WEST SUSSEX COUNTY COUNCIL CONSULTATION

TO:	Arun District Council FAO: Michael Eastham
FROM:	WSCC - Highways Authority: Tim Townsend
DATE:	9 November 2020
LOCATION:	Land south of Ford Lane East of North End Road Yapton BN18 0DS
SUBJECT:	Y/105/20/DOC Approval of details reserved by condition imposed under Y/80/16/OUT relating to condition 10- Construction Method Statement. More information received.
DATE OF SITE VISIT:	19 October 2020
RECOMMENDATION:	More Information Required
S106 CONTRIBUTION TOTAL:	£ See outline consent.

This is the third WSCC County Highway Authority (CHA) response to the above planning application for approval of details reserved by condition imposed under Y/80/16/OUT relating to condition 10 - Construction Method Statement (CMP). Previous CHA comments were made in response dated 19th October 2020 and 29 October 2020 and this response should be read alongside those.

P:118-344 - Ford Lane, Yapton\Tech\Acad\Drawings\700 Series (Ford Lane Construction Access)\18-344-704 Construction Access Construction Makeup.dwg

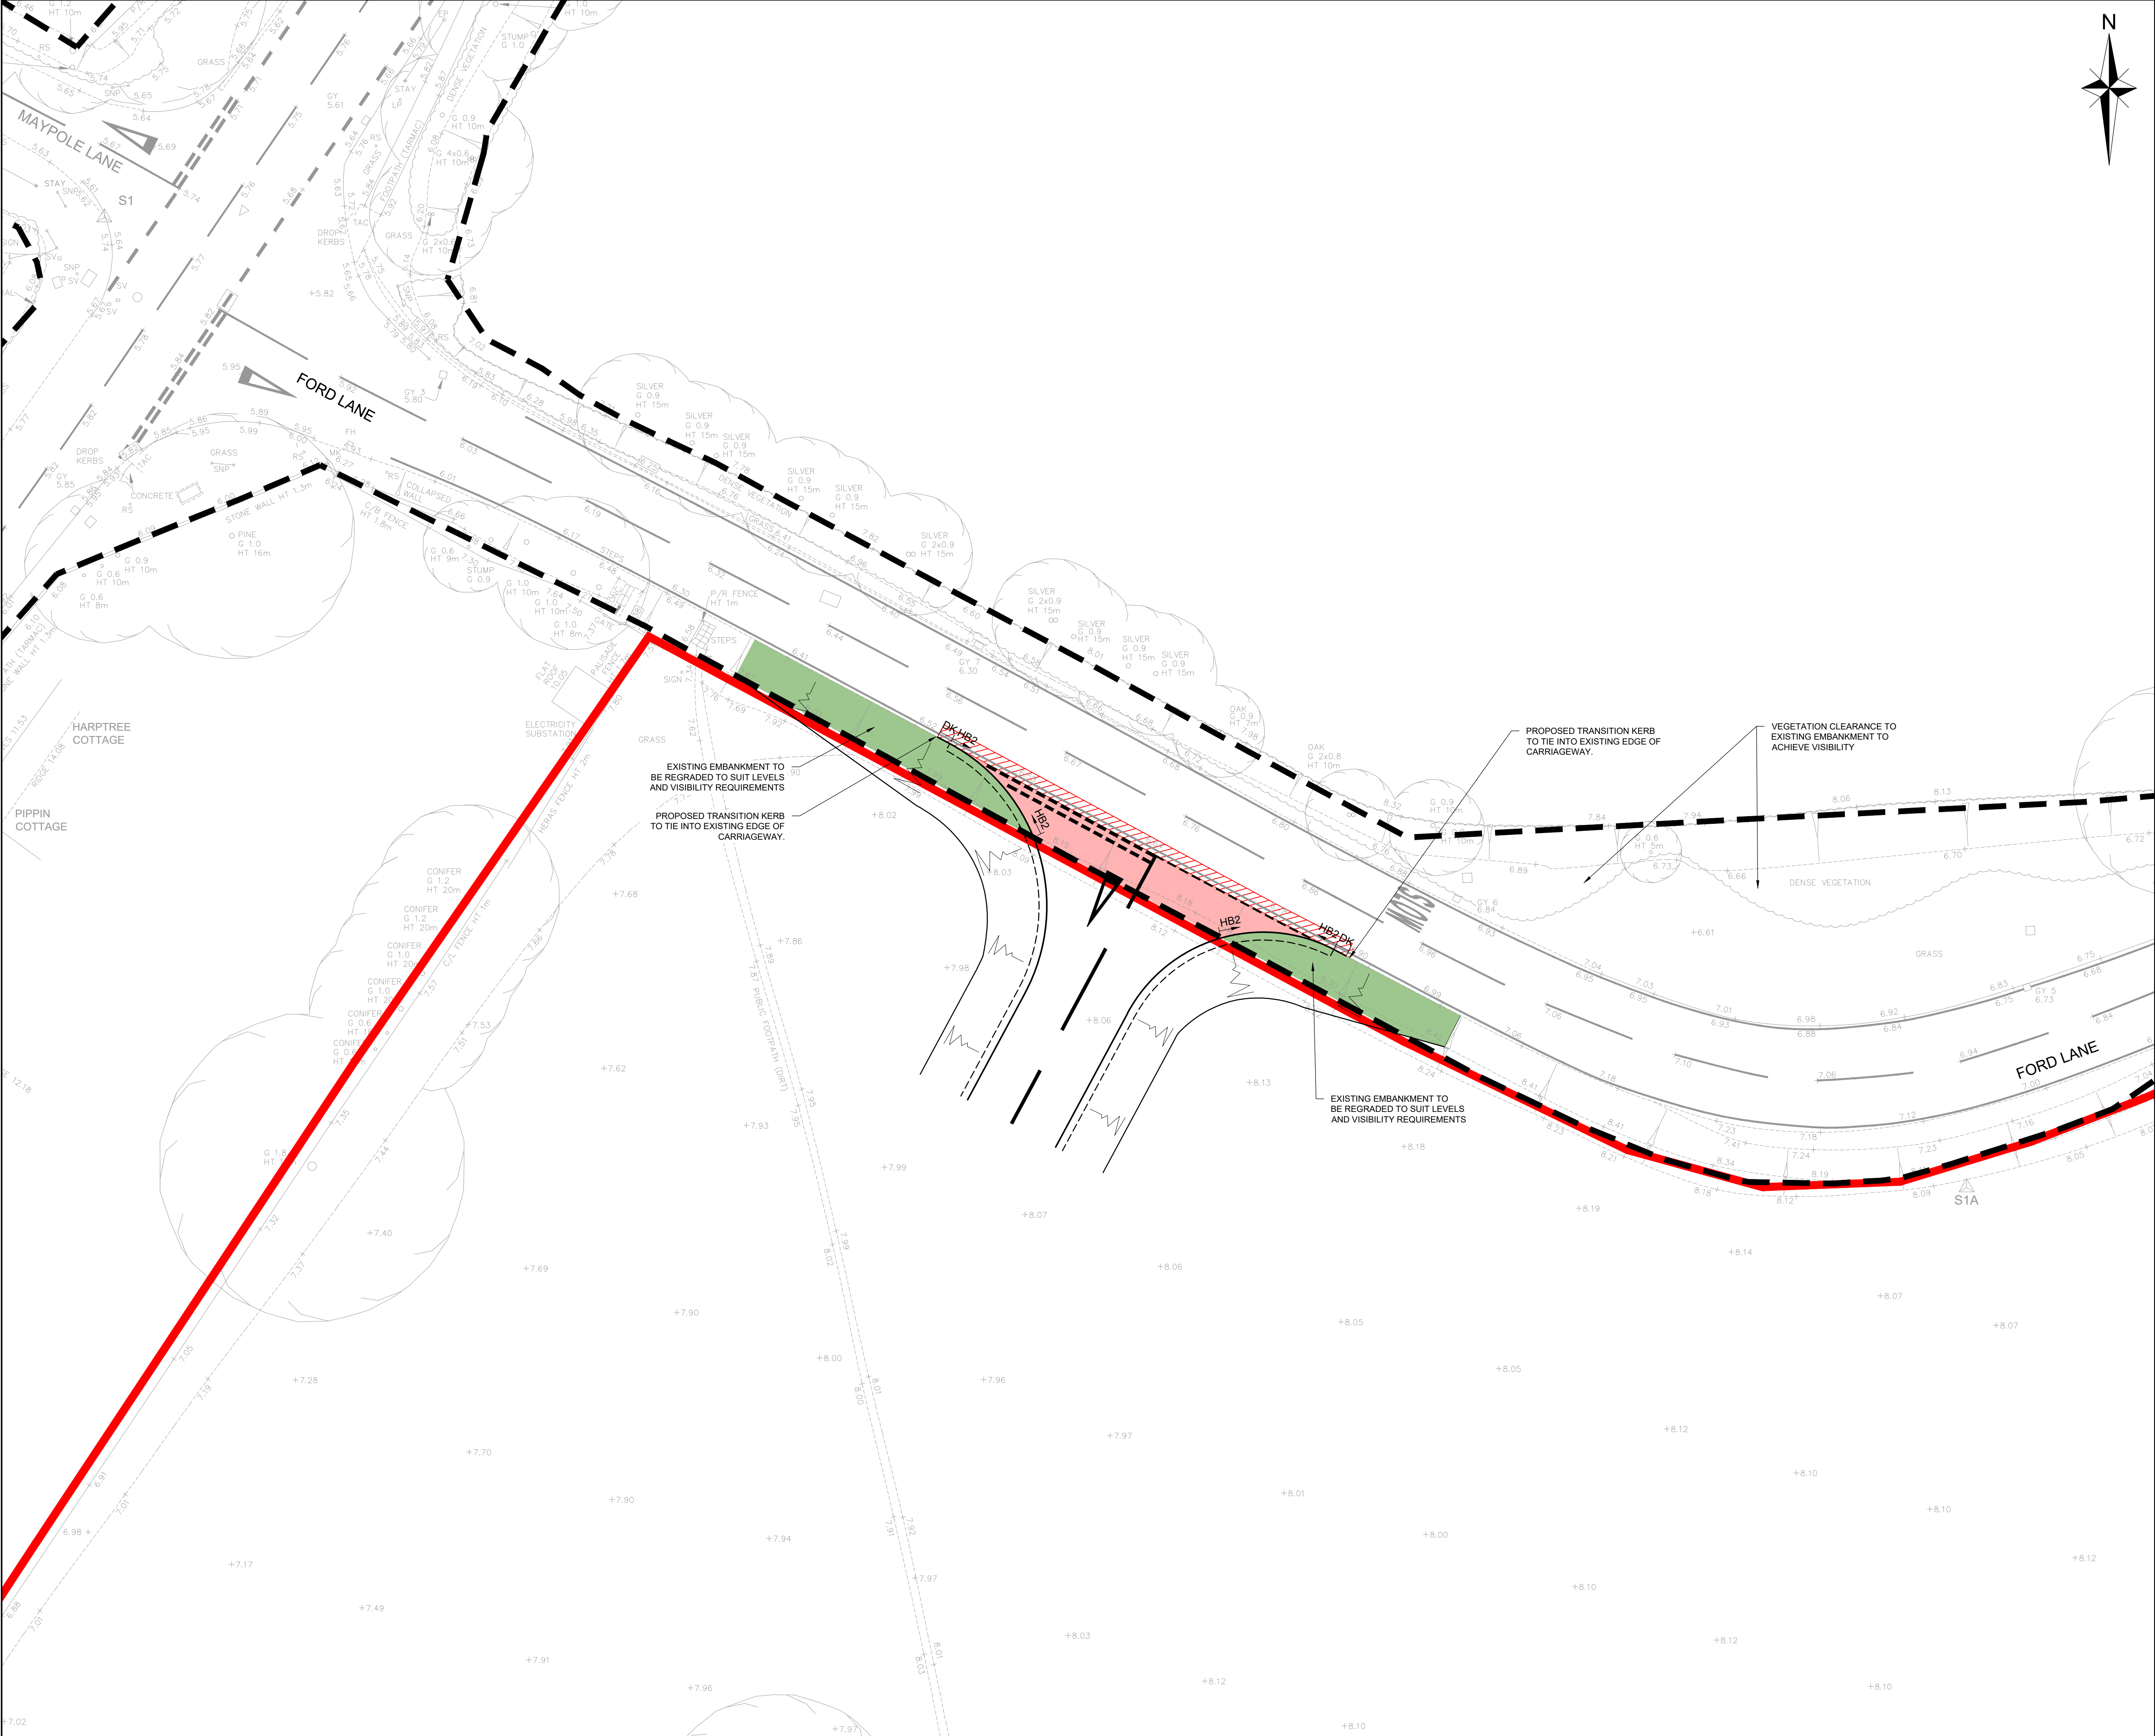
- ***‘Problem’ 3.1.1 – Risk of ponding of surface water*** – The designer’s response is not accepted by the CHA. As the access will be a new hard surface, surface water run-off will increase. As such, drainage will be required to ensure that ponding does not occur on the highway at the point the new access joins it. Designer to confirm what is to be provided and where (e.g. gulleys, check drains etc.).
